NON-MATERIAL AMENDMENT APPLICATION

I am writing to formally submit an application for a non-material amendment attached to the approved planning permission (2024/61/90058/W) for Penistone Road/ Rowley Lane, Fenay Bridge. This is to amend the front elevations of two house types (Avocado and 2B3P). The justification for the NMA is as follows:

2b3p End

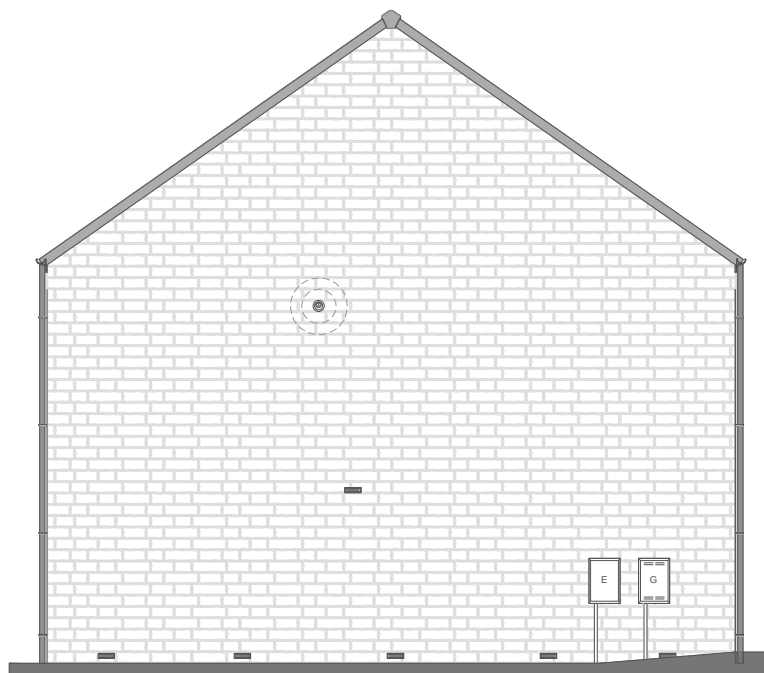
- Both house types were approved with a small ground floor window on the front elevation. Since then, these house types have been updated so that the ground floor front elevation windows have increased in size. Example snippets have been pasted below.
